**CITY EAST ZONE SUBSTATION &
INTEGRATED COMMERCIAL DEVELOPMENT
33 BLIGH STREET**

ACCESS REVIEW

FINAL v2

9 September 2011

- Ausgrid Stratum Area
- Tower Stratum Area
- Shared Stratum Area

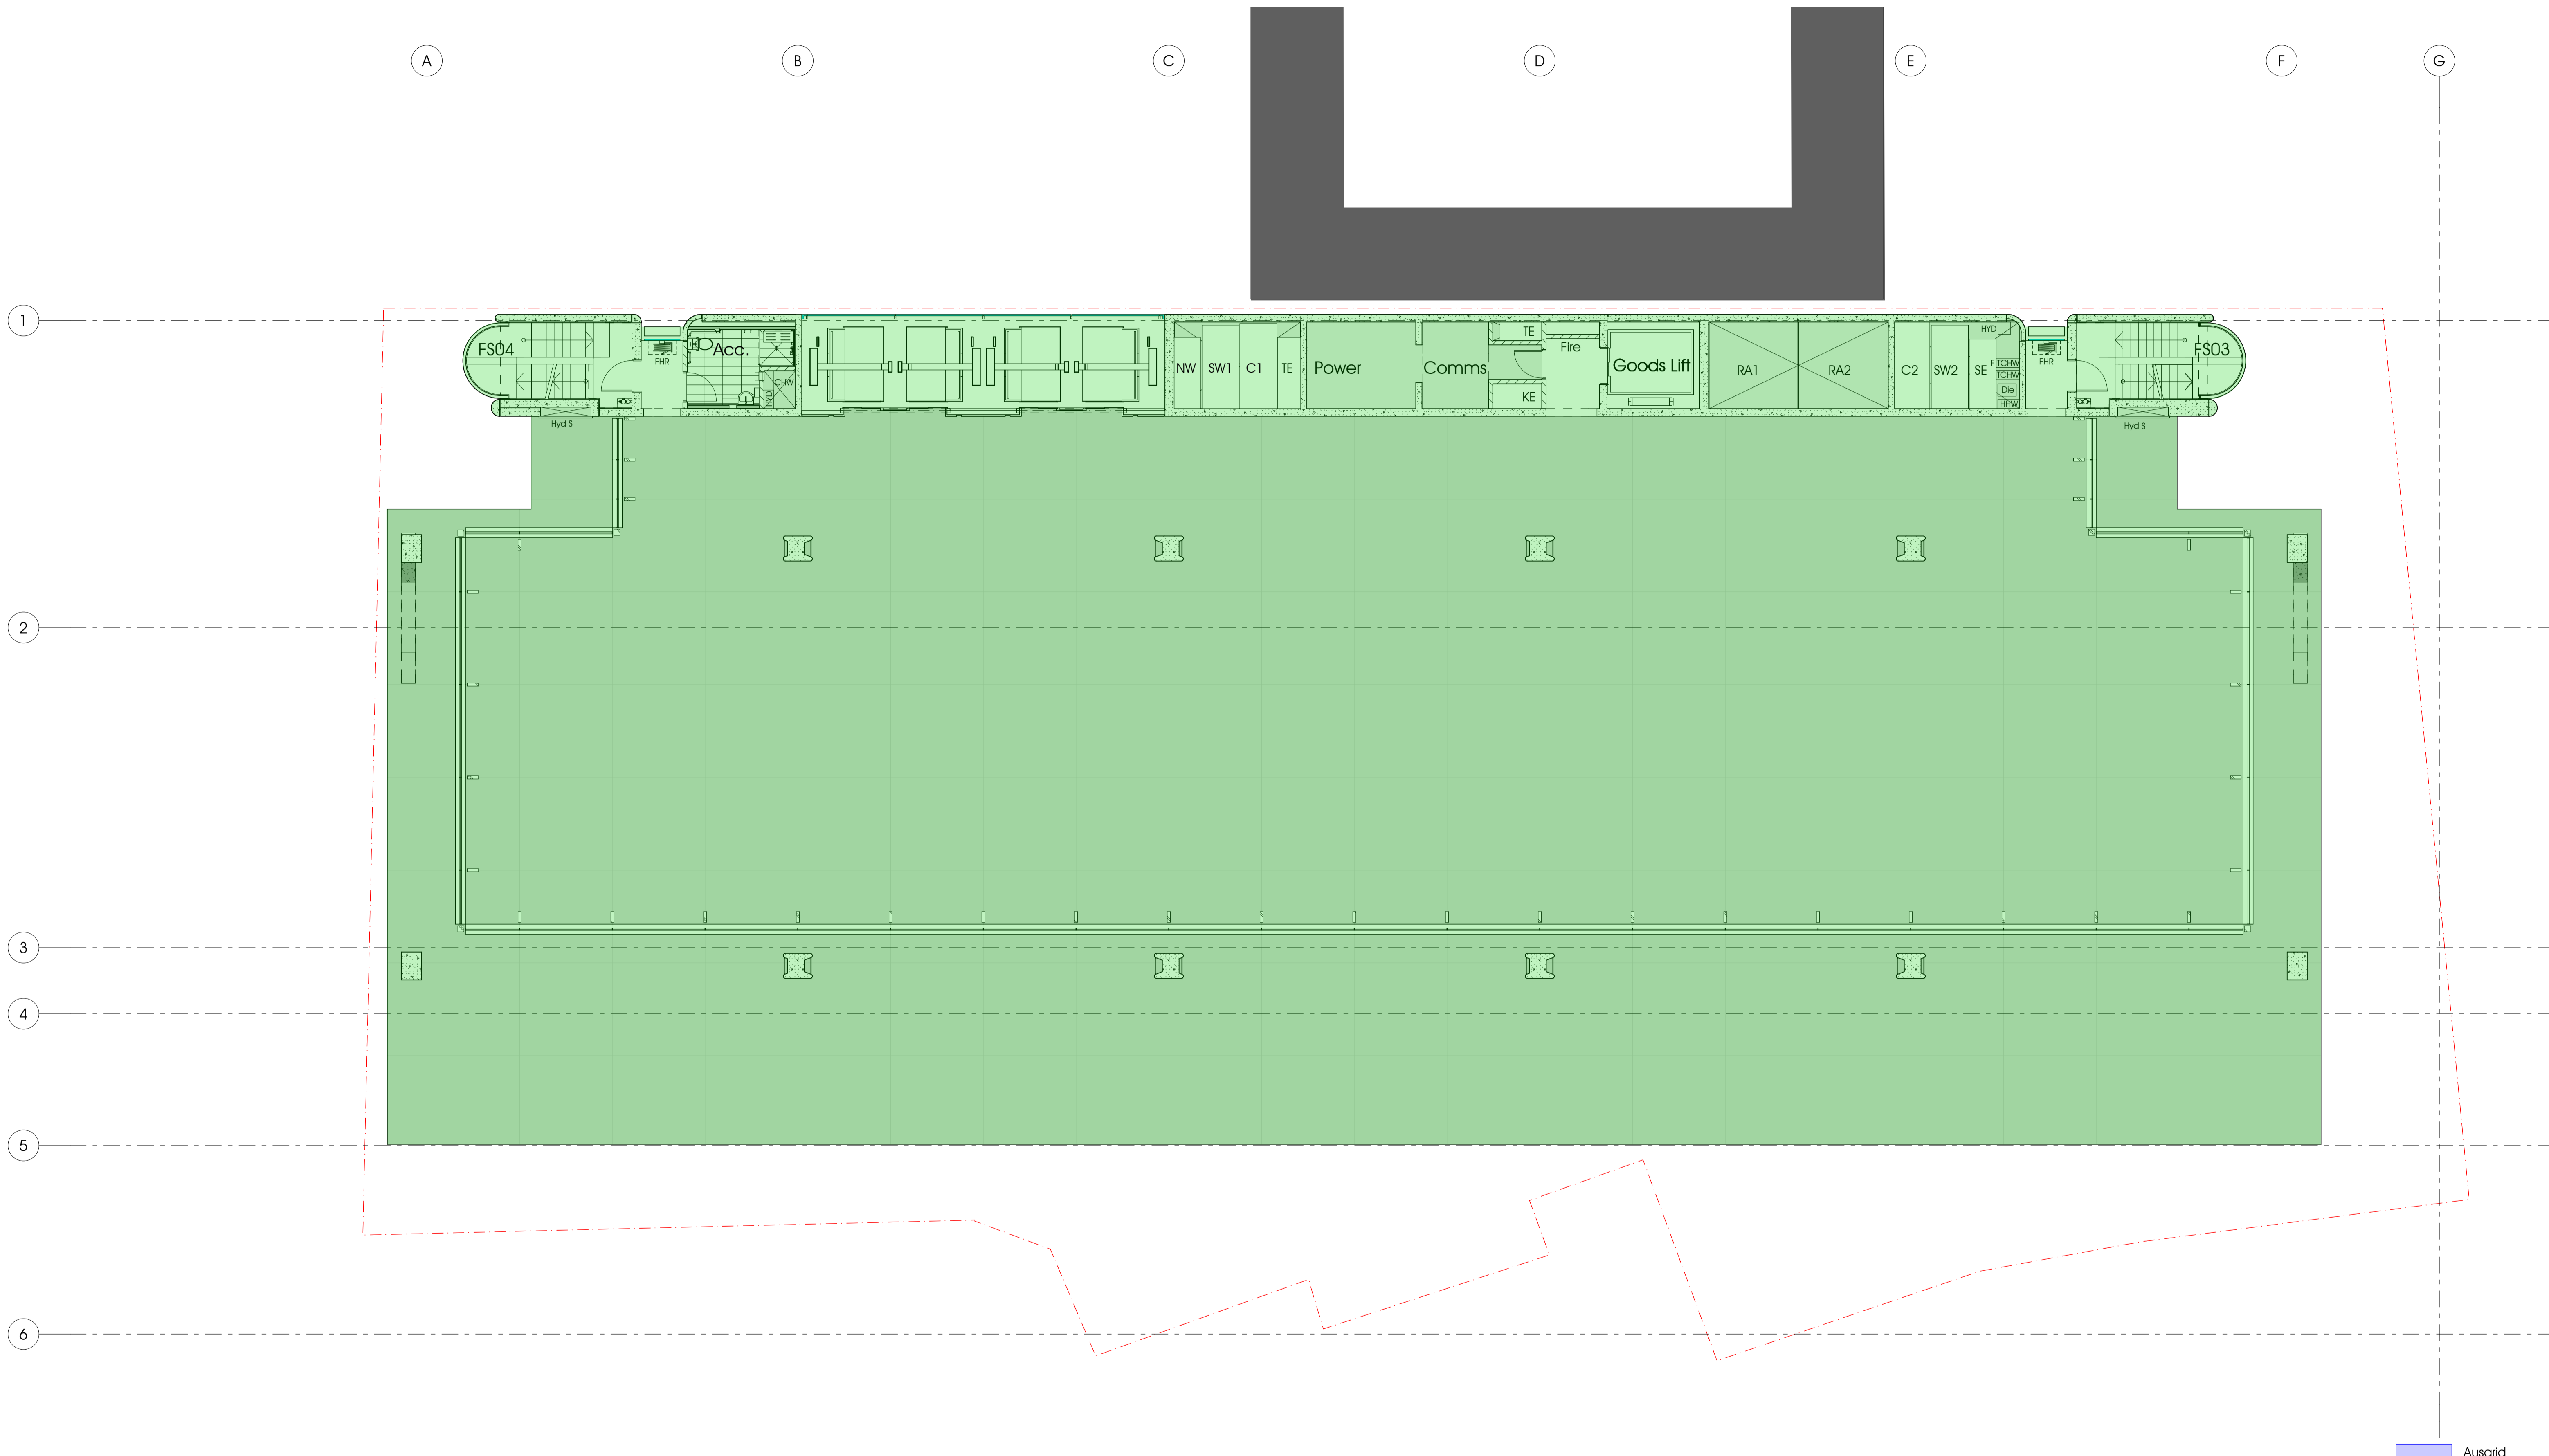
- (i) Ensure the following office and meeting room doors have a minimum 510mm latch side clearance in order to comply with AS1428.1:2009, fig. 31;
 - Level 07, accessible WC: currently none.
 - Level 14, accessible WC corridor door (GZ08): currently 300mm.

There is a stair located on the external seating area of the Sky Lobby. The stairs provide access to the level 13 male and female amenities area.

- (i) Ensure the stairs have closed risers in accordance with AS1428.1:2009.
- (ii) Ensure there are handrails on both sides of the stair compliant with AS1428.1:2009.
- (iii) Ensure there are tactile ground surface indicators (TGSIs) at top and bottom of the stair in accordance with AS1428.4.
